H. B. ZACHRY COMPANY REQUEST FOR INFORMATION ADDISON AIRPORT TUNNEL 171

ZACHRY-MONTEREY REQUEST FOR INFORMATION ADDISON AIRPORT TUNNEL - JOB #9080.01 173

NORTH TEXAS TOLLWAY AUTHORITY ADDISON AIRPORT TUNNEL

RFI# 171 - 184

**B** SECTION AT TUNNEL SUMP PIT  
 P147 1/4" = 1'-0"

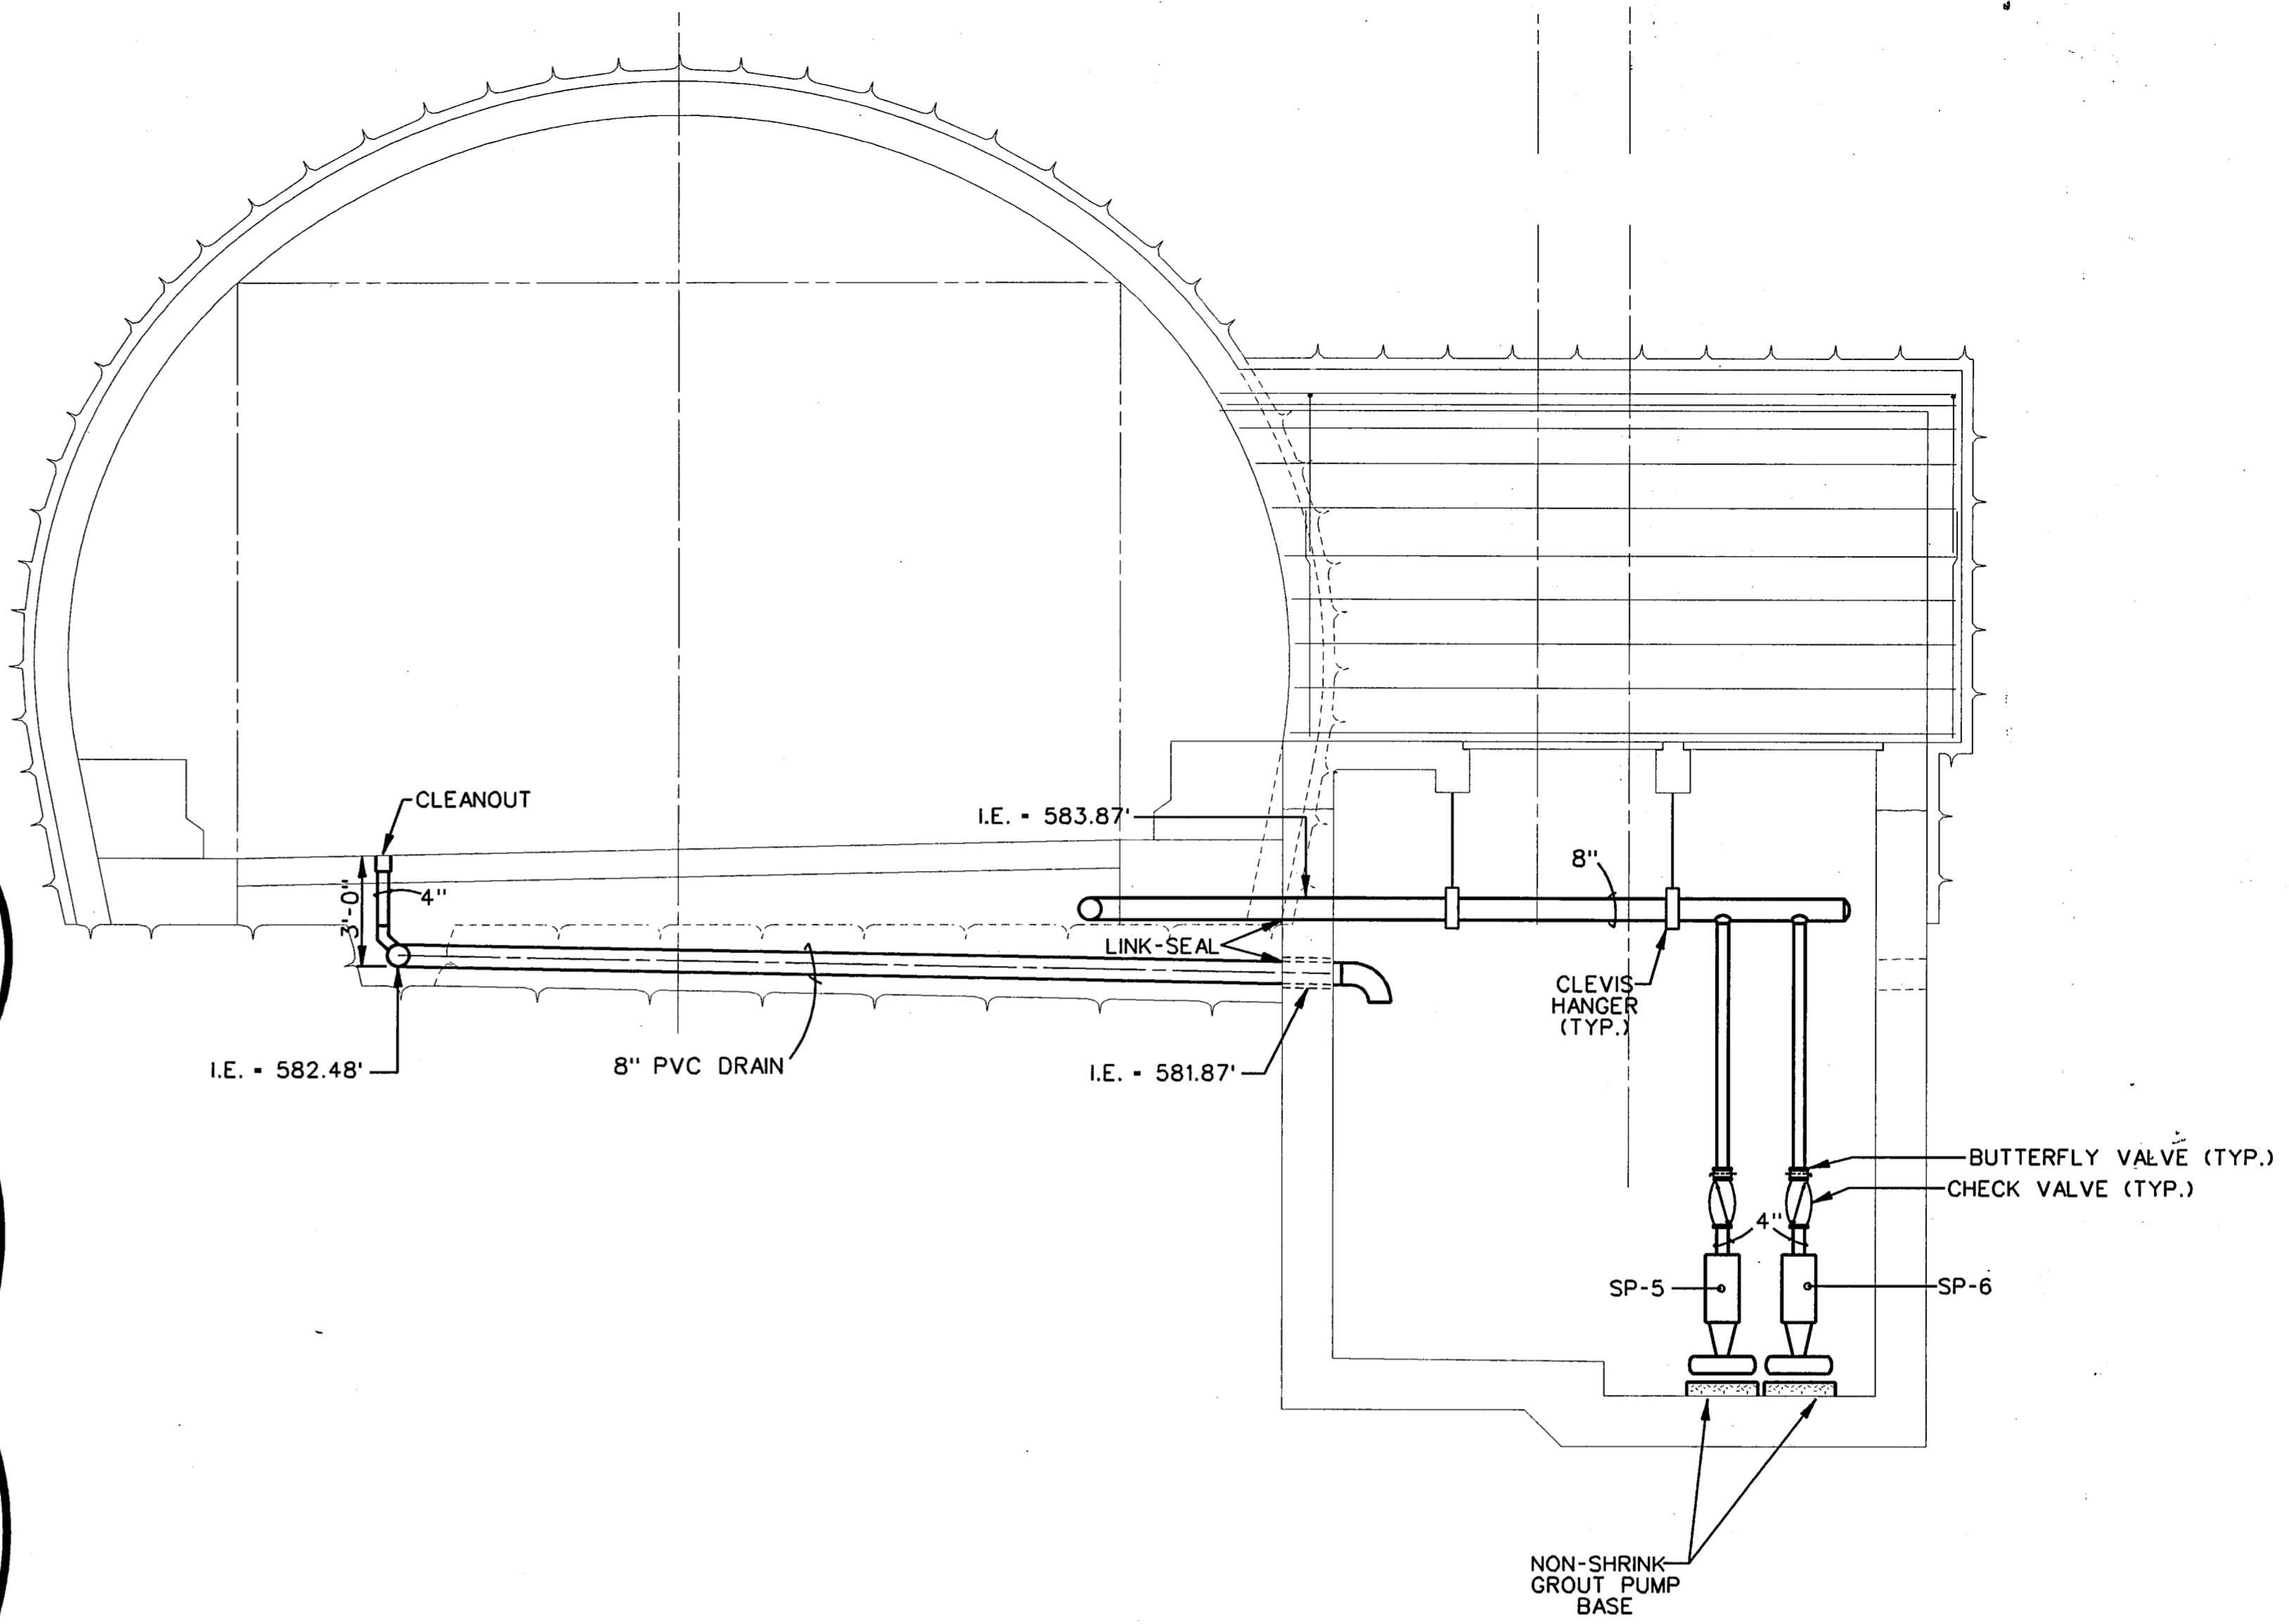
Problem: The flow line of the 20" discharge pump is shown to be 58.5' on sheet P147. The flow line of the 20" discharge pump is shown to be 58.5' on sheet P147. The flow line of the 20" discharge pump is shown to be 58.5' on sheet P147.
